# Comments for Planning Application 23/01960/FUL

Application Number: 23/01960/FUL

Address: Wild Briars Goverton Bleasby NG14 7FN

Proposal: Erection of 2 no. dwellings, with detached double garages, new private access road to private drive

TITLE:
PROPOSED DRAINAGE & LANDSCAPING

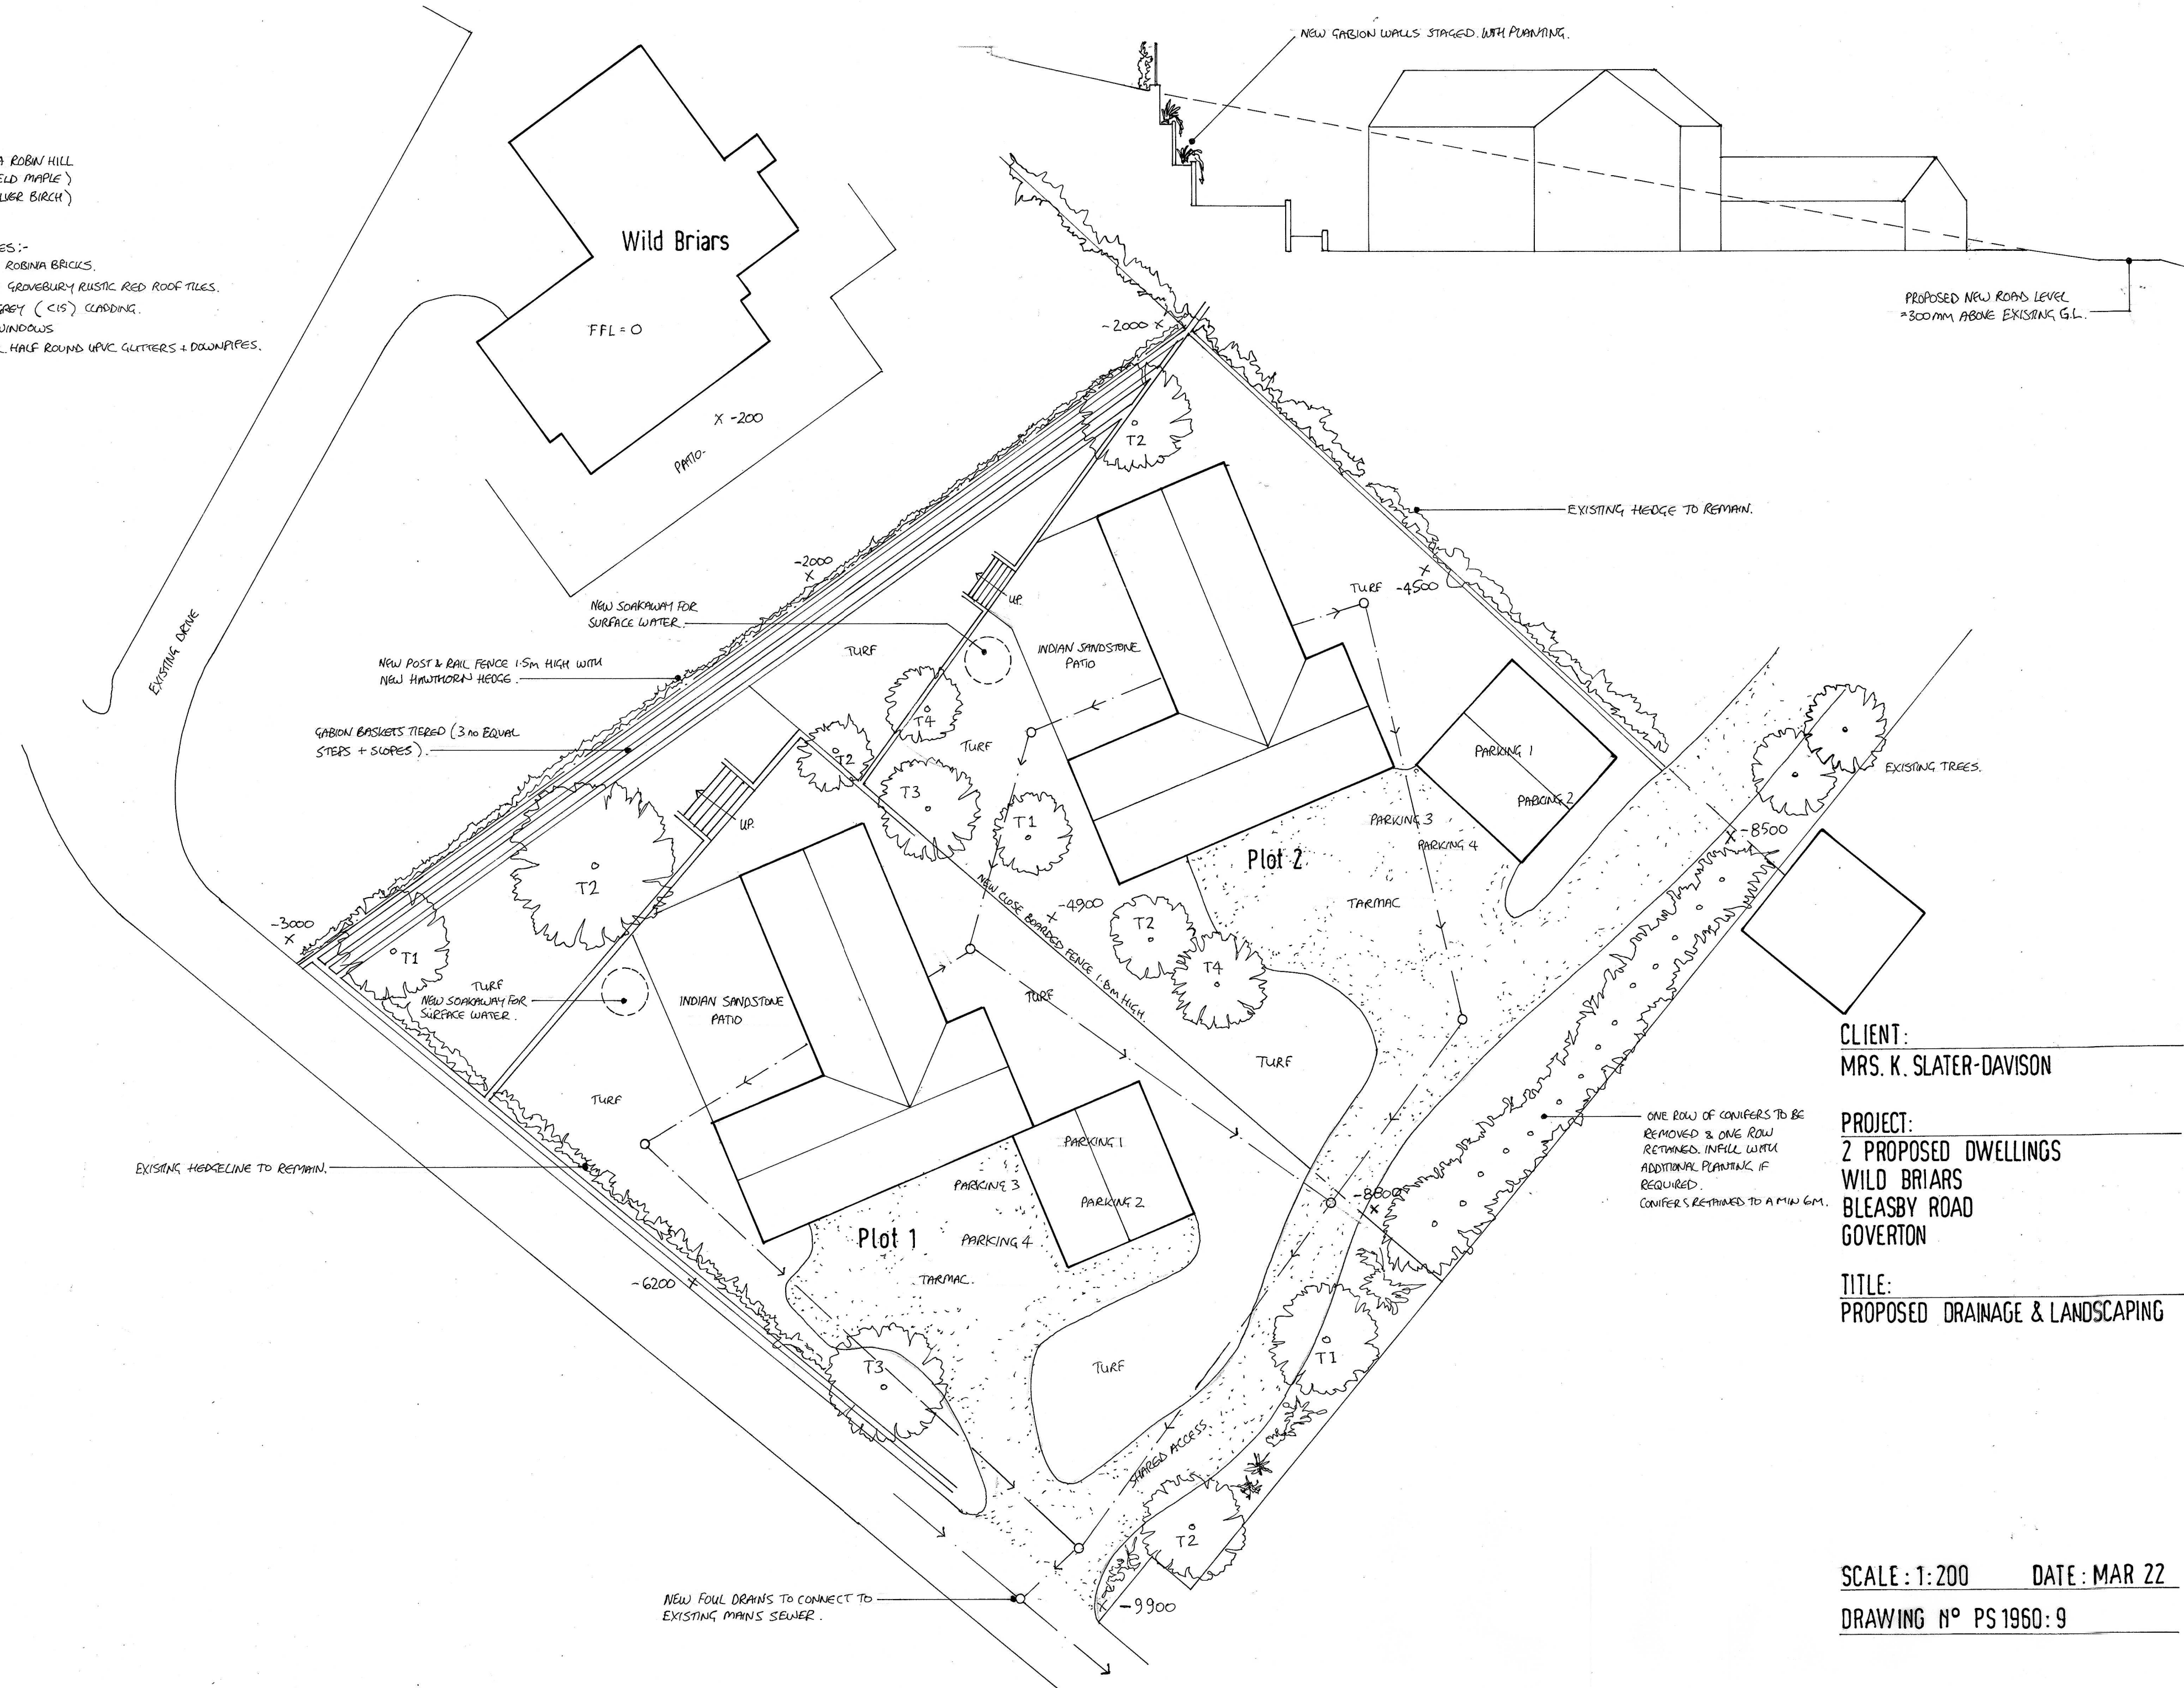
Comment:Whilst pleased to see the use of a hydrobrake in the drainage strategy as a resident of Bleasby in the catchment area of a frequently overwhelmed Severn Trent pumping station (that has in the past overwhelmed properties in the village) I have to ask whether any connection to the mains sewer for surface water run off is advisable? Any addition of hardstanding and surface water drainage from this development will simply add more load to the Shale Lane / Manor Close pumping station burden - which simply cannot cope in times of stress. Have other SUDS solutions been considered that would negate this impact been considered? I will look out for both Severn Trent and Nottinghamshire County Council (as the Lead Local Flood Authority) comments on this application.
